BM:LD:AA | SSD-29508870

9 November 2022

**SUBJECT: BIRRIWA SOLAR FARM (SSD-29508870)**

Thank you for providing Mid-Western Regional Council (Council) with the opportunity to provide comment on the Environmental Impact Statement (EIS) Birriwa Solar Farm (SSD-29508870). Council has reviewed the document and provides the following comments.

BARNEYS REEF ROAD - MC01

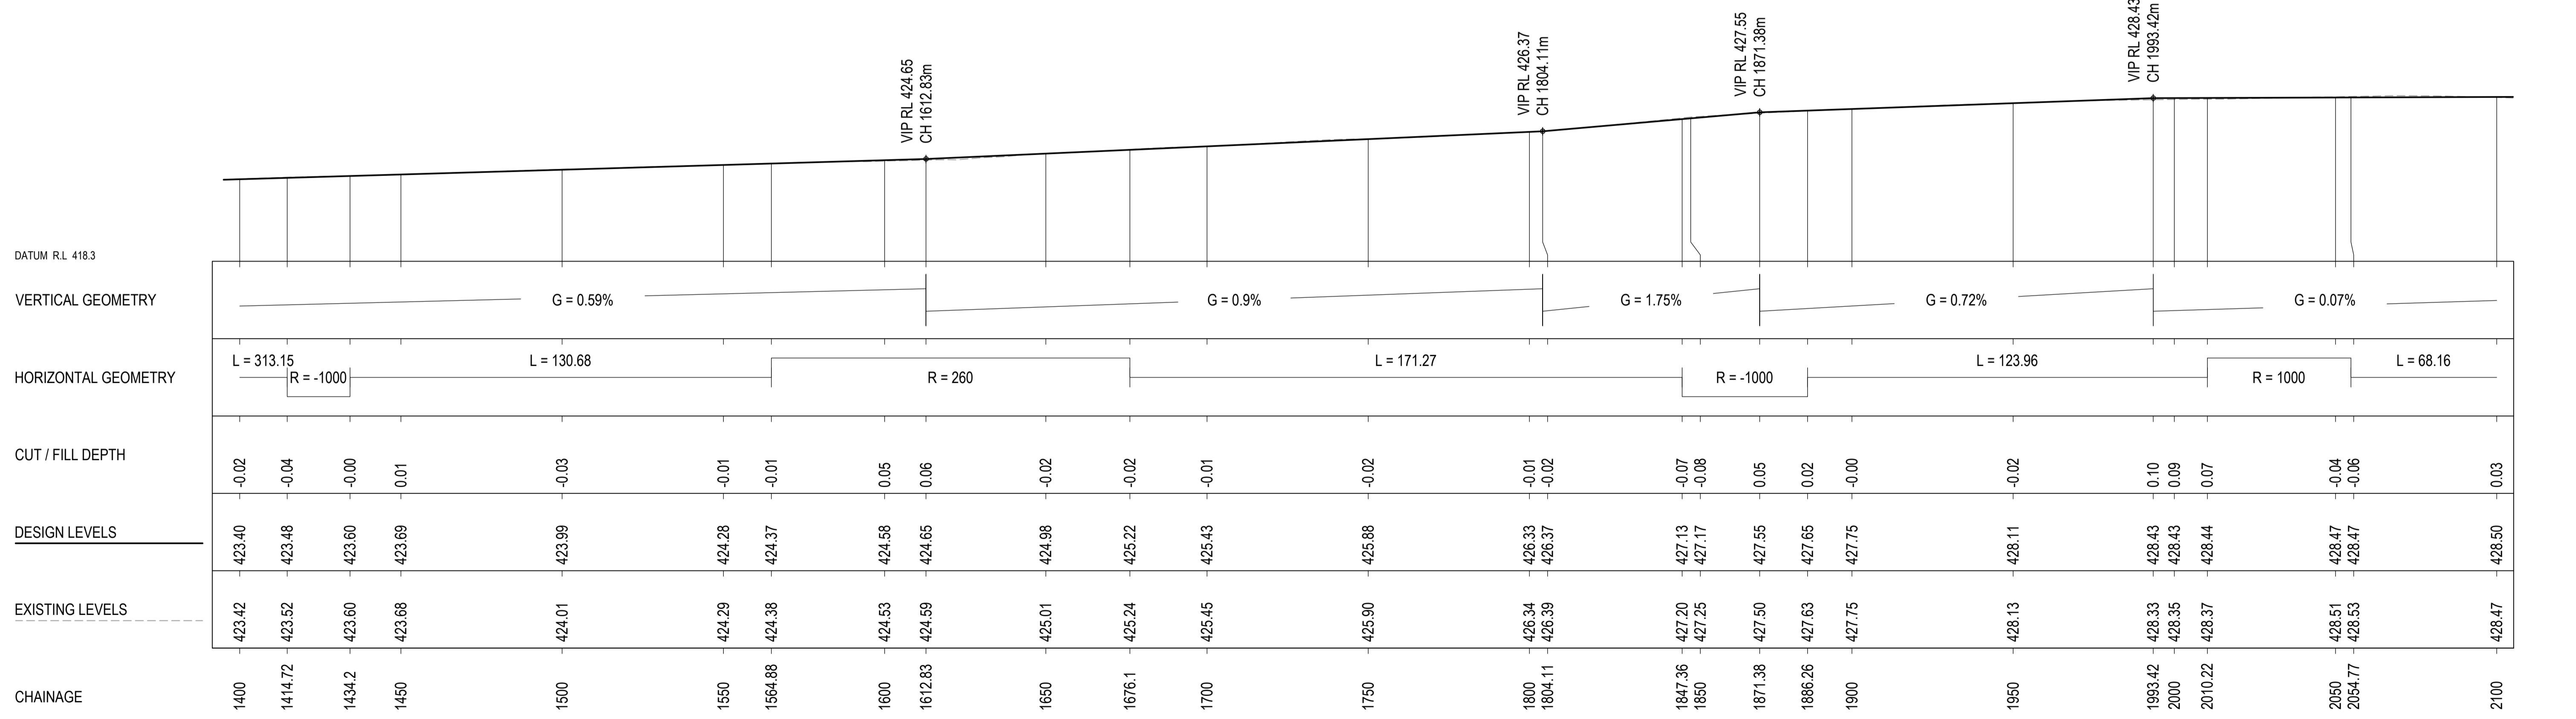
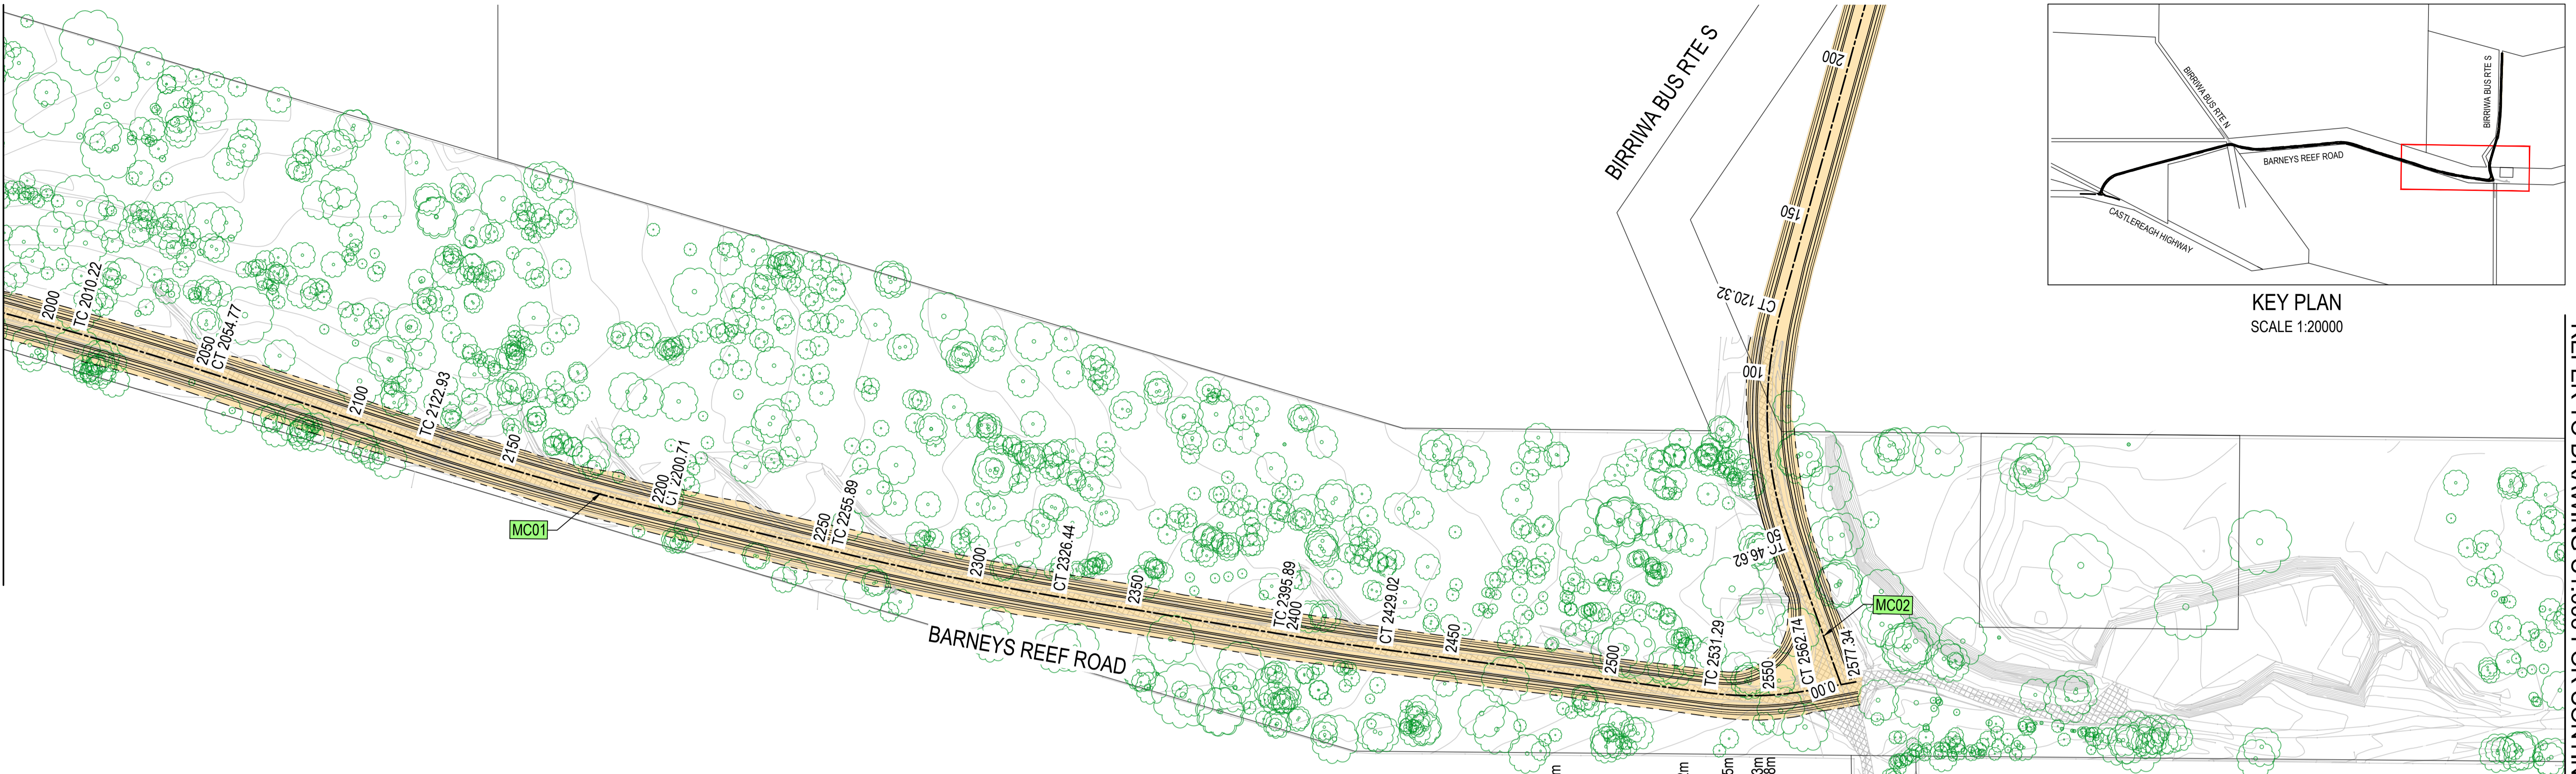
Barneys Reef is deemed to be a suitable access road subject to the following;

- Road widening is conducted where required with minimal impact on trees
- Small piped culverts are installed where required
- The mitre drains are deepened
- The road pavement receives additional gravelling for the traffic loadings and sealing
- The pavement thickness is determined by a geotechnical assessment
- The intersection of Barney Reef Road and Castlereagh Highway is referred to Transport NSW for consideration and conditioning

Further, the pavement on the Birriwa Bus Route is to be of the same standard as Barneys Reef Road and the existing concrete culvert is to be assessed for structural adequacy.
